EA reference: PA-0011443/01

LPA reference: H06-0819-26

Change of use of land to a residential caravan site comprising 4 Gypsy/Traveller pitches, each accommodating a static caravan/mobile home and a touring caravan, together with hardstanding, erection of 4 amenity buildings and improvement of existing access - retrospective Land south of Blazegate and West of Gedney Drain, Gedney, Spalding

Environment Agency position

Figure 3 – SFRA 2115 Residual Peak Depth Map (0.1% Annual Probability)

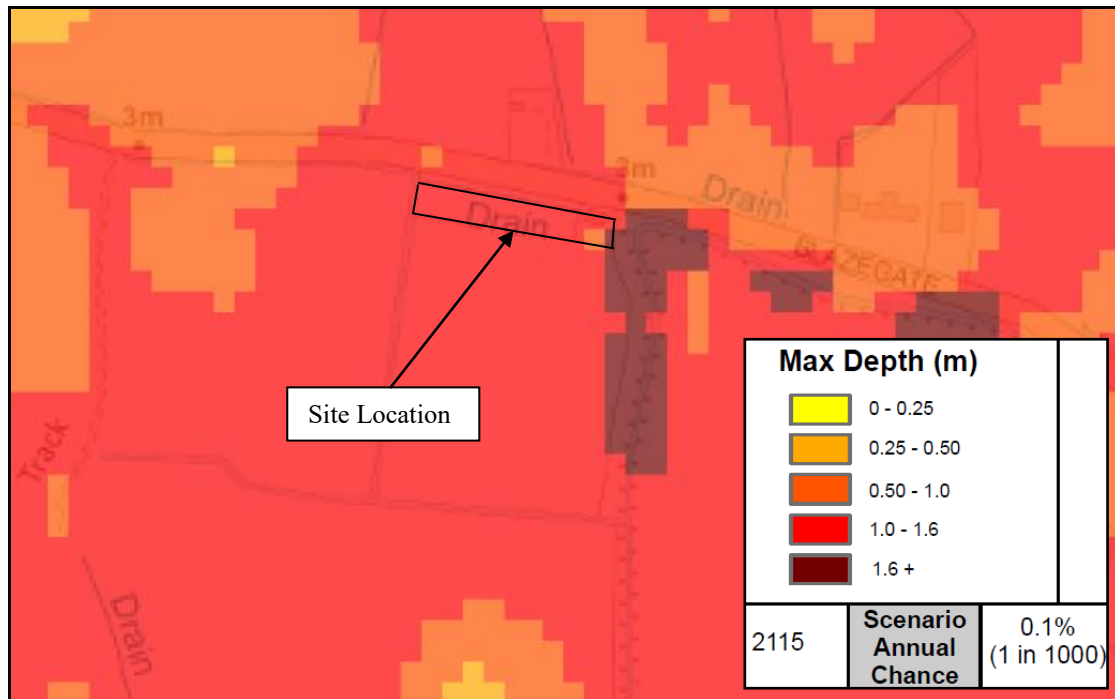
In addition, as outlined in the submitted flood risk assessment, the site has a future hazard classification 'Danger for Most' (includes the general public) and could experience flood depths of 1.0 – 1.6m arising from a breach in the defences during a flood that has a 0.1% chance of occurring in any one year up to 2115.

Notwithstanding the flood risk mitigation measures, we consider that the development poses an unacceptable risk of flooding to people.

Whilst the flood risk assessment outlines there would be sufficient time to take precautionary actions in the event of a flood, our data indicates that the site would be inundated within 4-6 hours based on a breach at point 547208,329637. A breach in the defences can happen at any time and there is no guarantee that there would be sufficient time for warnings to be issued or for safe evacuation of the site during a breach.
